I write to formally object to the determination of planning application 2024/91236 (Plot 23, Lingards Road) under delegated powers. The proposal represents a material departure from the committee-approved full permission for the site and meets multiple thresholds under Kirklees Council's Scheme of Delegation that require referral to the District Wide Planning Committee.

Project :	Housing at Lingards Road, Slaithwaite.		
Client :	SB Homes.		
Drawing :	Plot 23 - Alternative layouts with garage.		
Scale :	1:100.	Date :	Nov 2023
Dwg No :	2019 572 Sk 13	Rev :	K

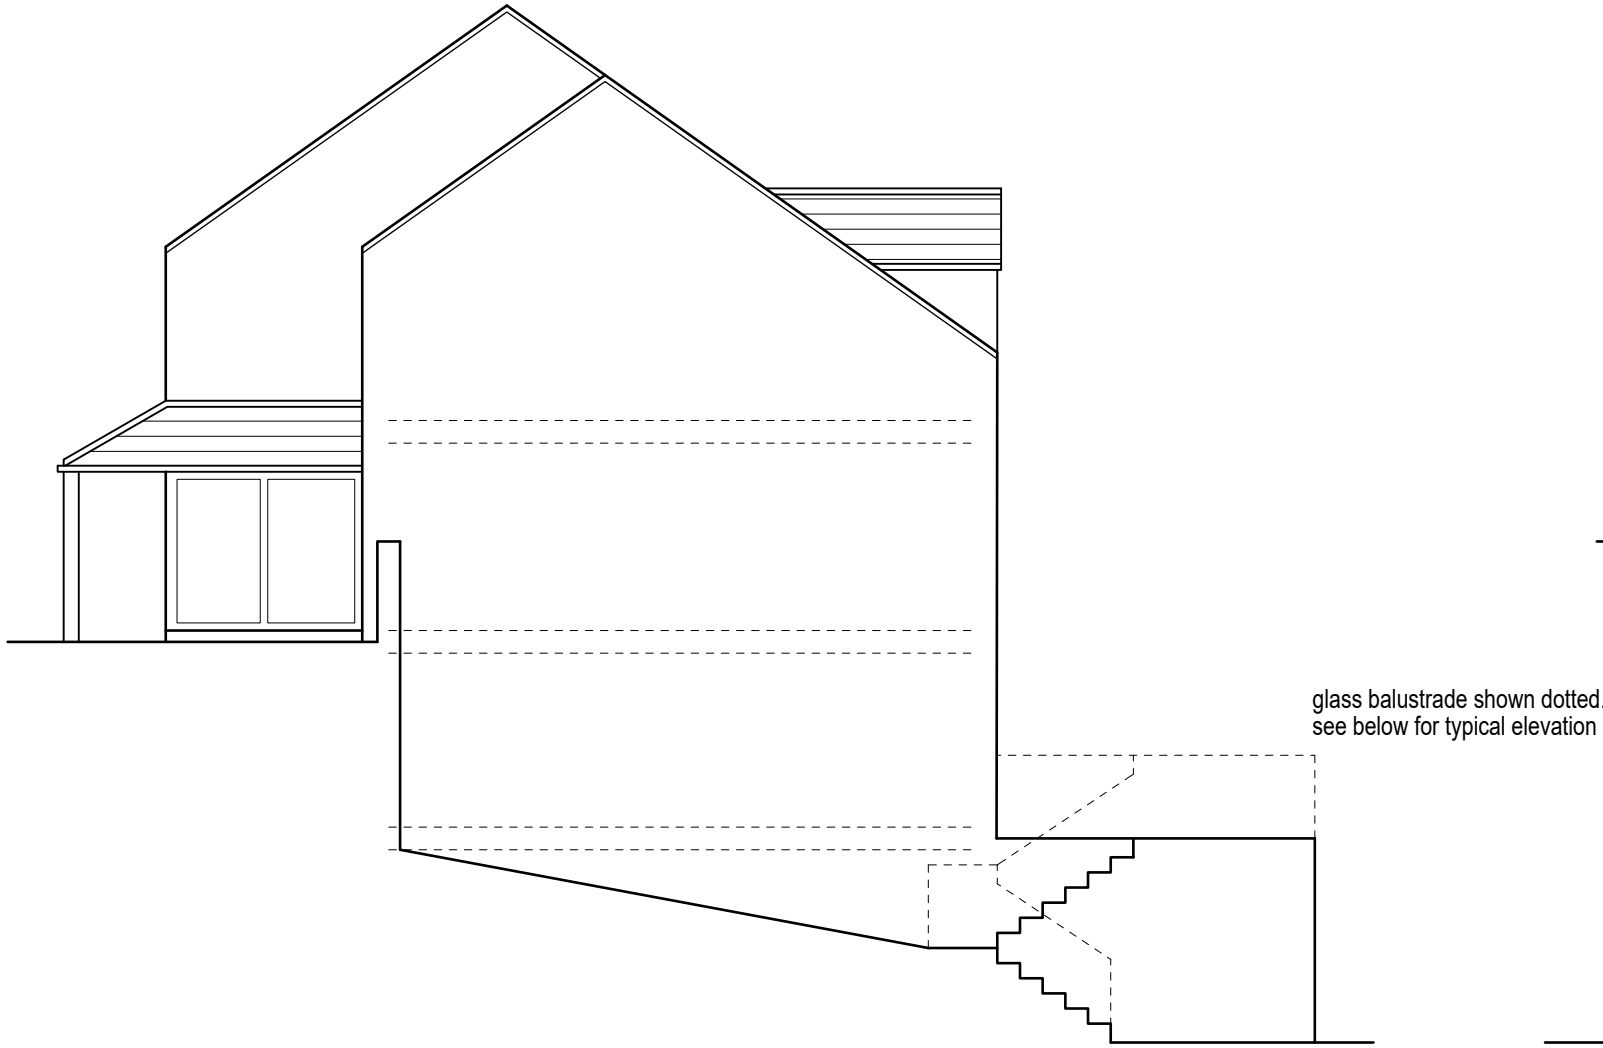
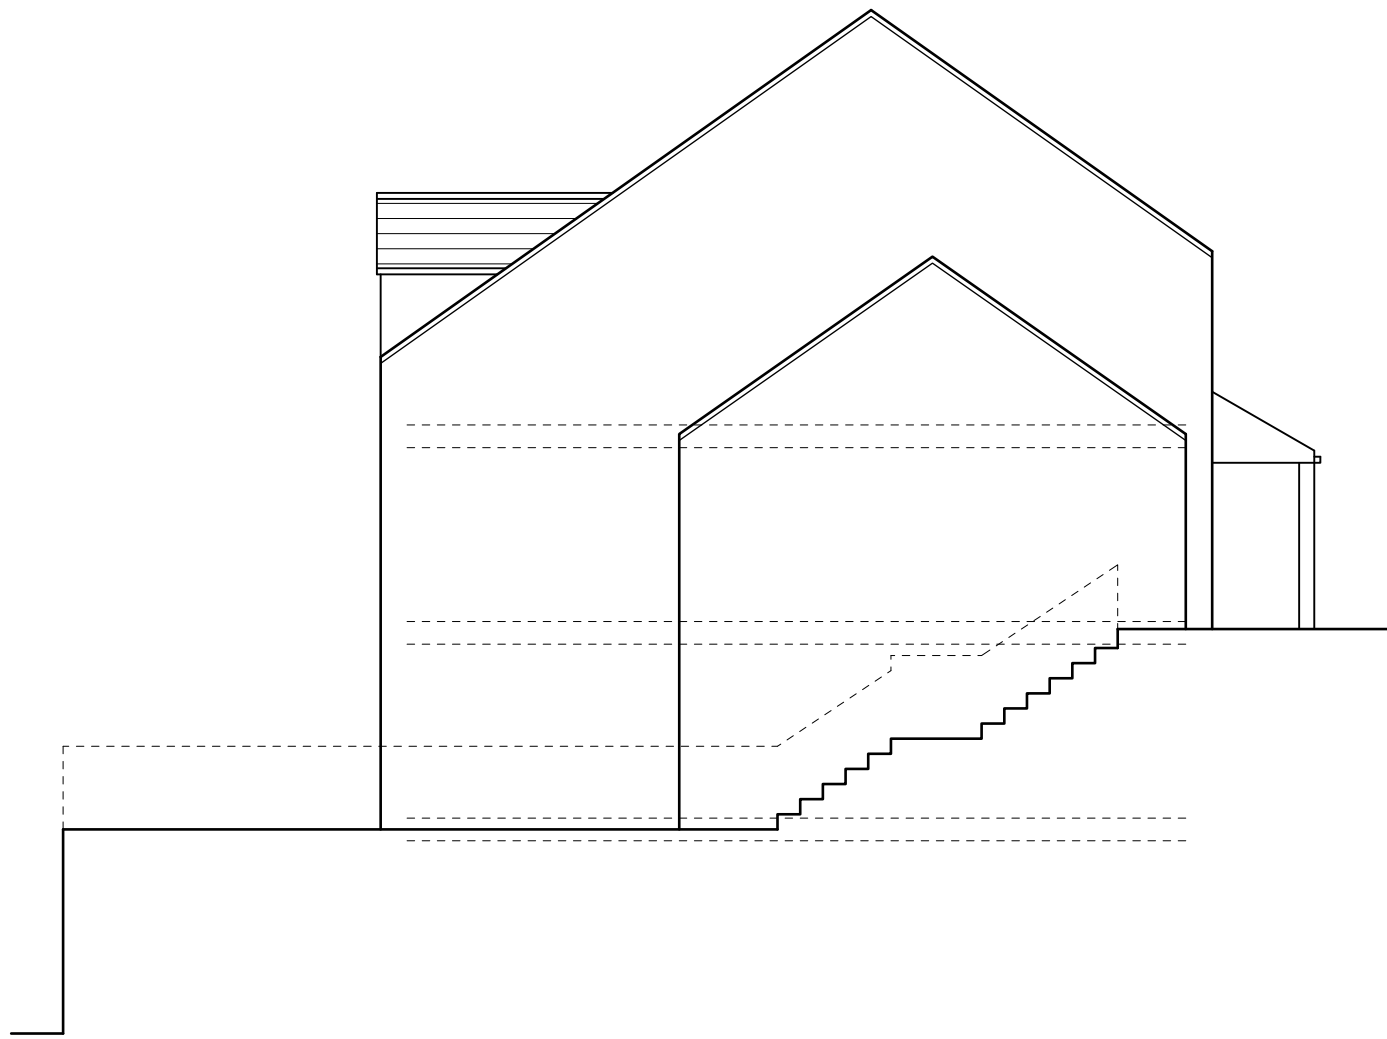
The original full permission for the site approved dwellings of two and three storeys, with massing and ridge heights designed to respect the surrounding context. The proposed dwelling at Plot 23 exceeds these parameters—standing noticeably taller (~2 metres) than the bungalow directly opposite. This represents a clear departure in scale and visual impact from what was originally approved.

Plot 23 occupies the **highest position on the estate**, making its scale and elevation especially sensitive. The lower floor, currently under construction, sits **above road level**, meaning the front door and garage will be raised significantly above the street. This creates a visually dominant and disproportionate presence on Lingards Road, which is otherwise characterised by modest, low-profile dwellings.
